**Our Ref: Y/19/18/L**

**Application for Listed Building Consent for Alterations, Extension or Demolition of a Listed Building**

**Development** Variation of conditions following a grant of planning permission Y/70/15/L relating to Condition 2 - Substitute plans to amend the design.

**Location** Hobbs Court Bilsham Road Yapton

East Elevation (front)
1:100 @ A3

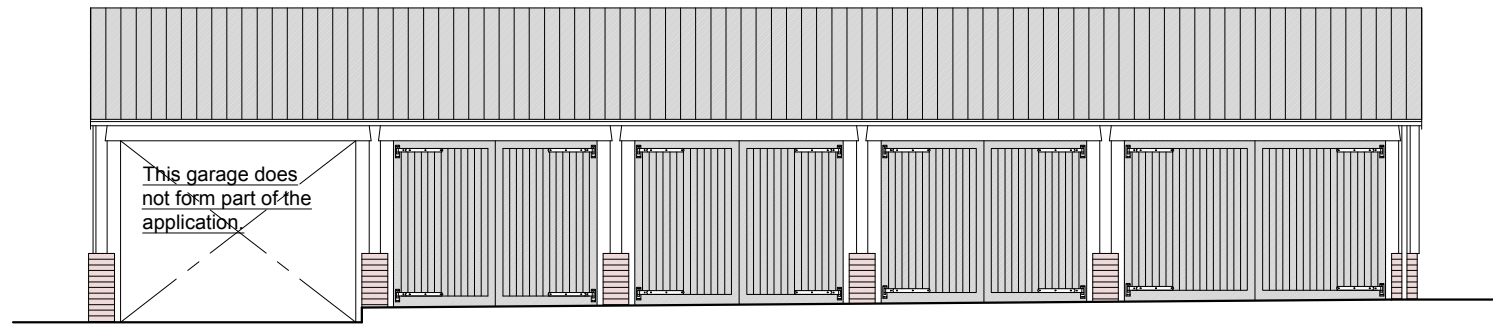
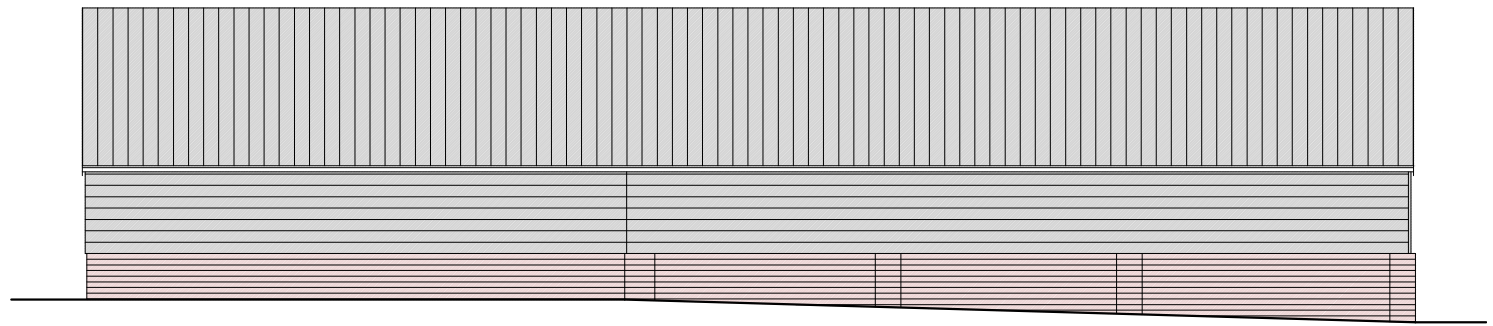
I have been advised by the Planning Officer that due to the red edge on this application being around the whole site, you will also need to serve notice on the properties 'Potting Barn' and 'Dovecote' and amend the Certificate B on the application form to add them accordingly. The planning officer has also requested that you annotate the East Elevation (front) for clarity, to state that the first garage does not form part of this application.
